CONSULTEE RESPONSE (Council's Arboriculturist)

Reference: BN/65/22/PL

Proposal: Sever land and erection of 1 No bungalow with new vehicular access (resubmission of BN/14/22/PL). This application is a Departure from the Development Plan and is in CIL Zone 3 and is CIL Liable as new dwelling

Location: Land at rear of Cedar End, Eastergate Lane, Eastergate, PO20 3SJ

Proposed Site Plan
1:200

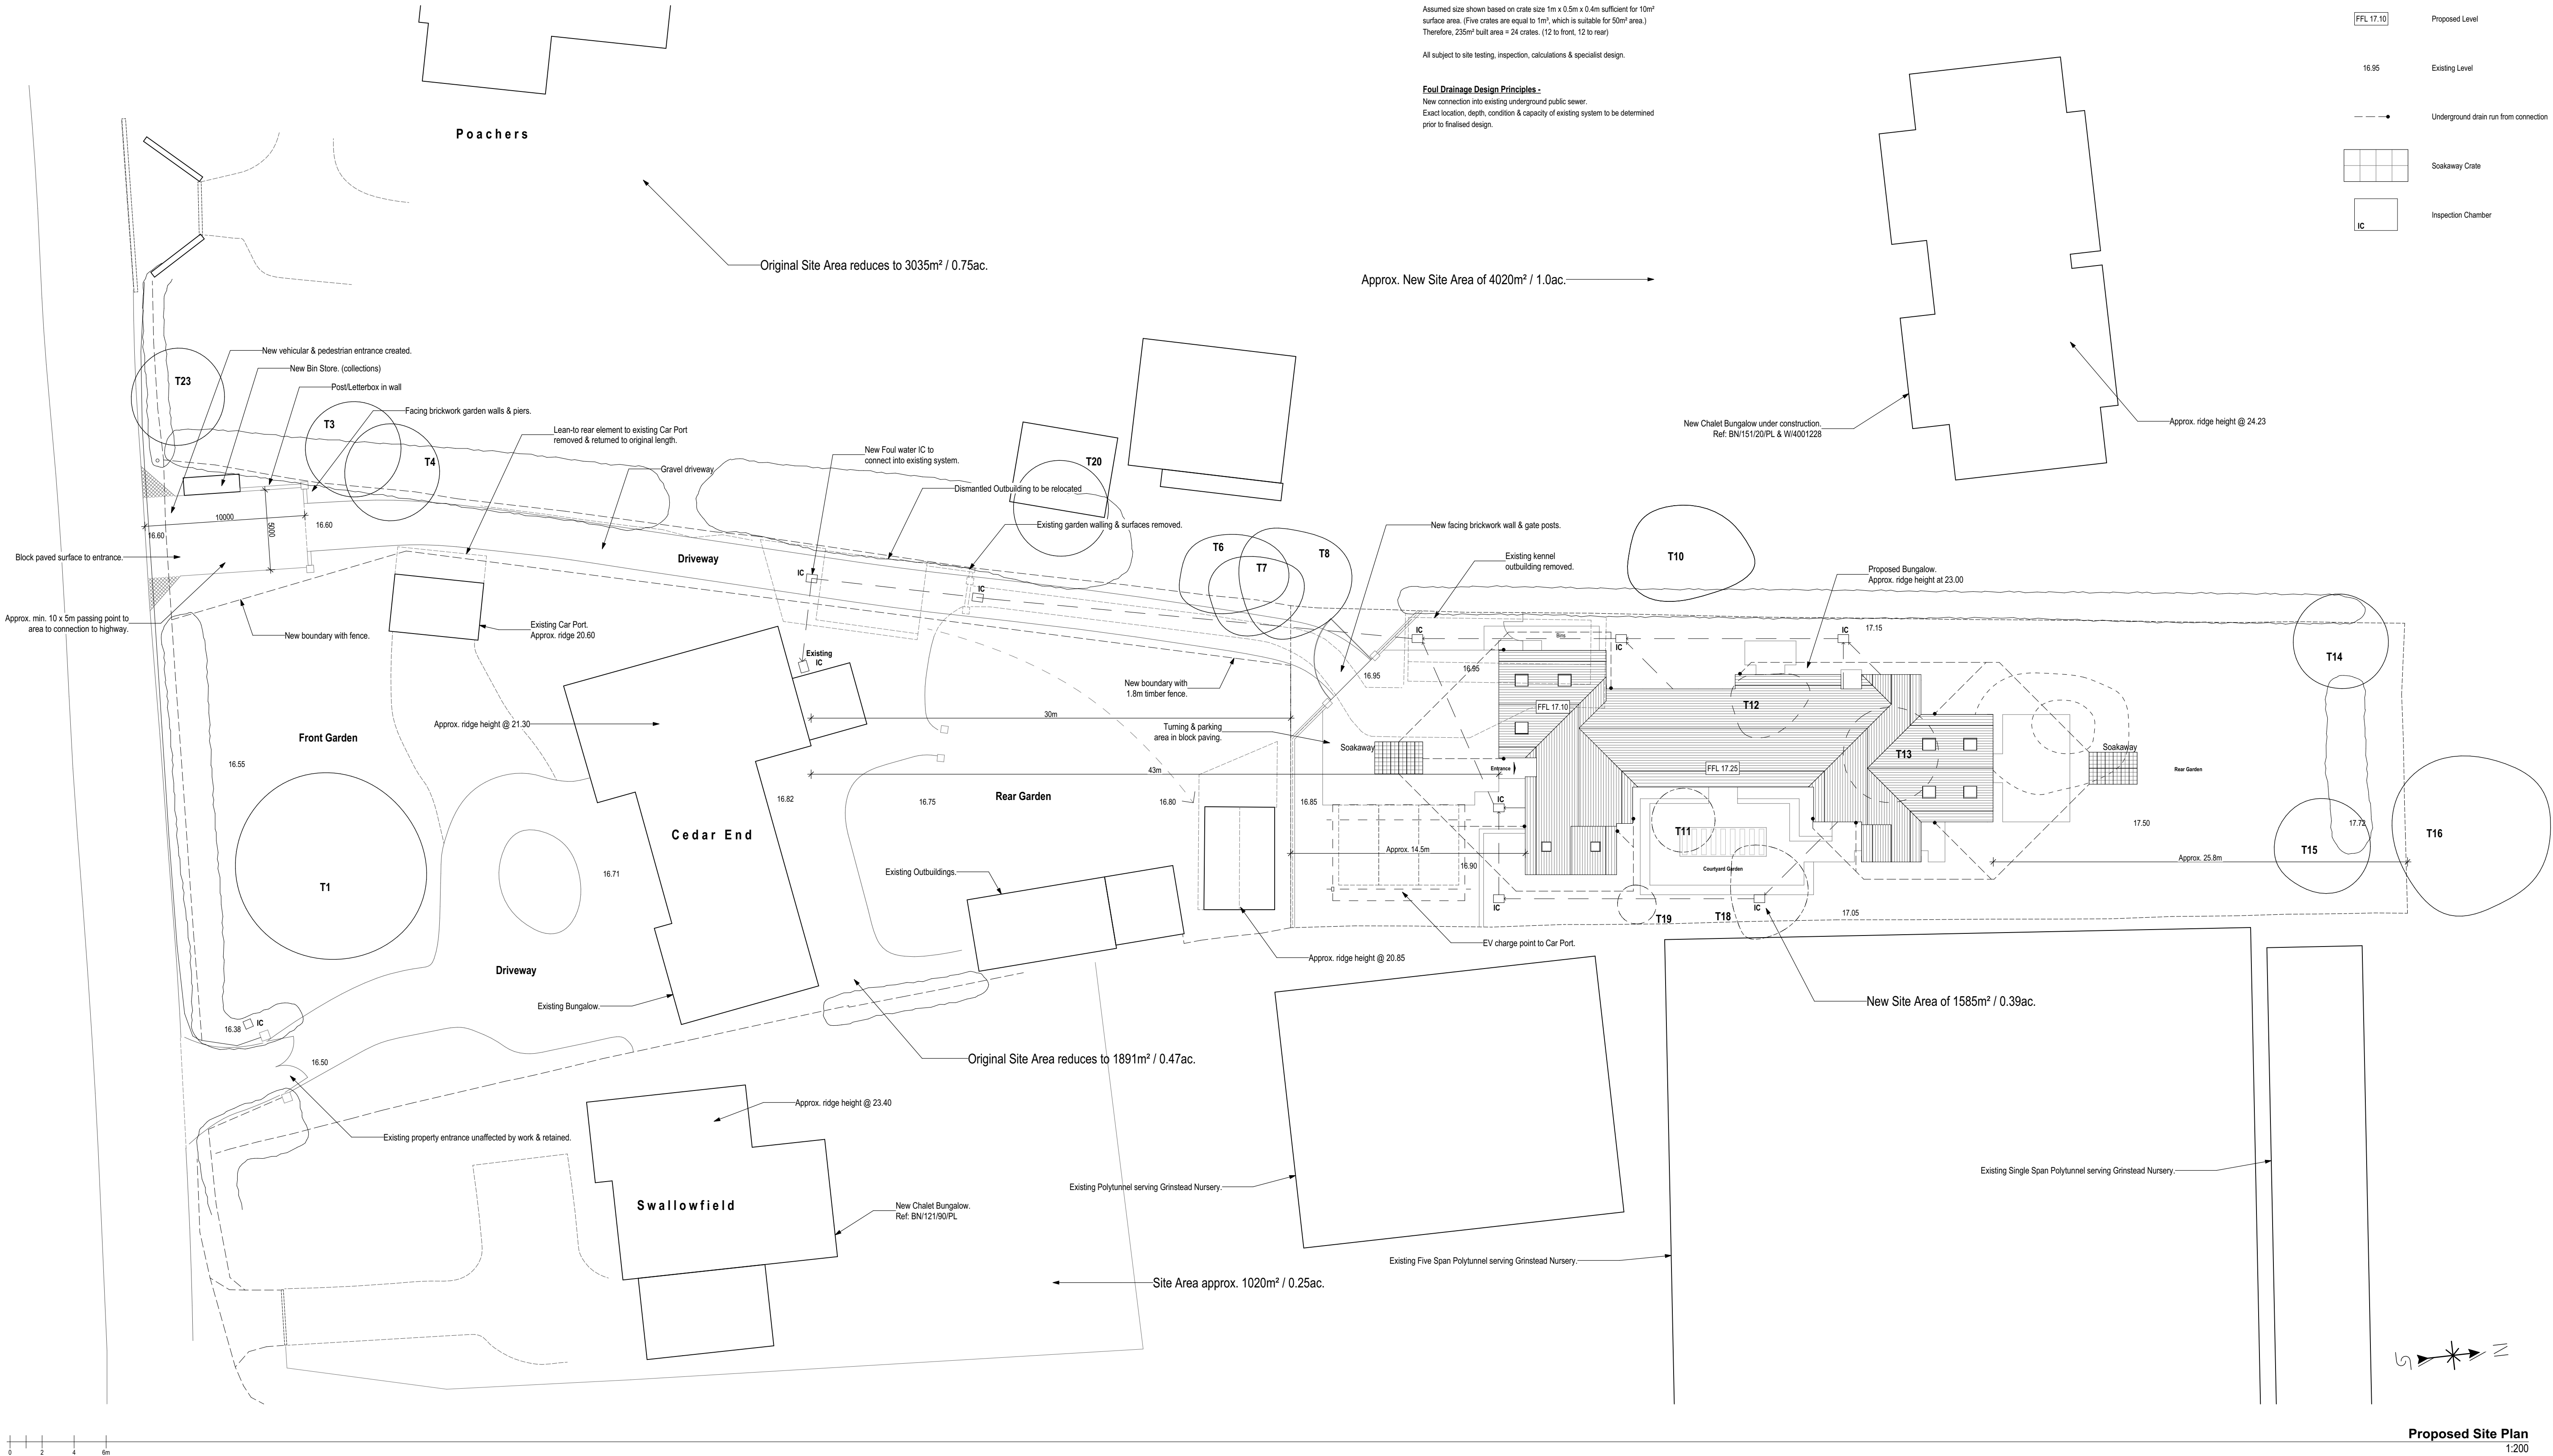
There does not appear to be a surface water drainage (and foul water sewer) strategy for the site.

I draw attention to the nominal root protection areas (RPA) of retained trees and their growth potential as obvious constraints to the siting of any SUDS feature, soakaway or introduction of subterranean utility apparatus.

Drainage and service-runs in and out of site have not been shown and so there remains a risk of root protection area incursion to satisfy those requirements.
